**ADC Planning Consultation
Response from the Historic Buildings Adviser**

Application Number	WA/54/13/L
Address	Smugglers Steps, The Street, Walberton, Arundel BN18 0PQ
Description	Application for listed building consent to demolish part of a failed boundary wall and rebuild as existing.
Case Officer	Cian Cronin
Site Visit	Previous

SECTION A 860mm HIGH B 1220 HIGH C 1370 HIGH D 1570 HIGH

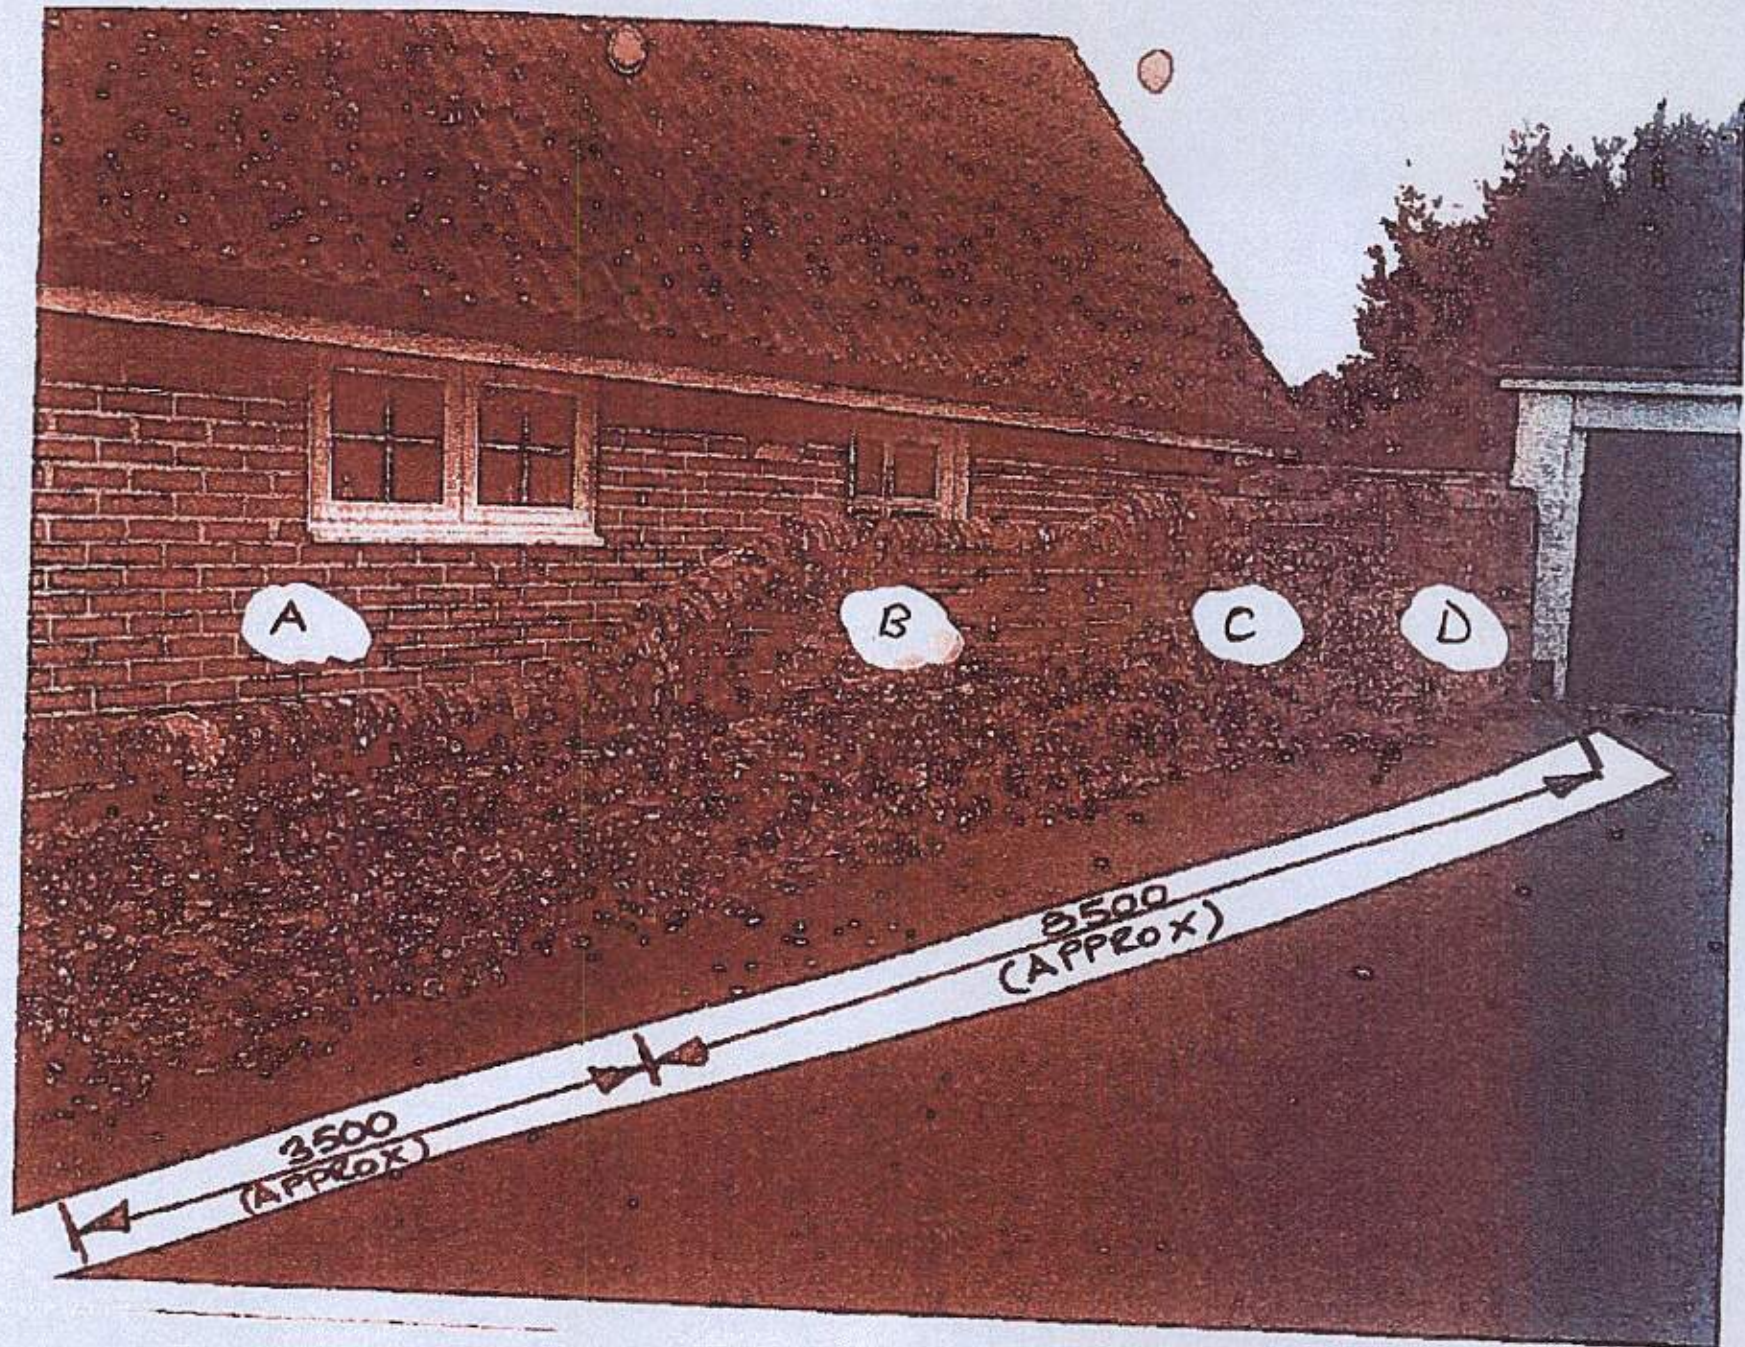
On the basis that this has been fulfilled, the wall should be constructed as close to the original as possible, which includes, use of material, construction and drops in level. These should be shown in a measured drawing with photographs to assist, so that the contractor can get as close as possible to the original. Please condition.
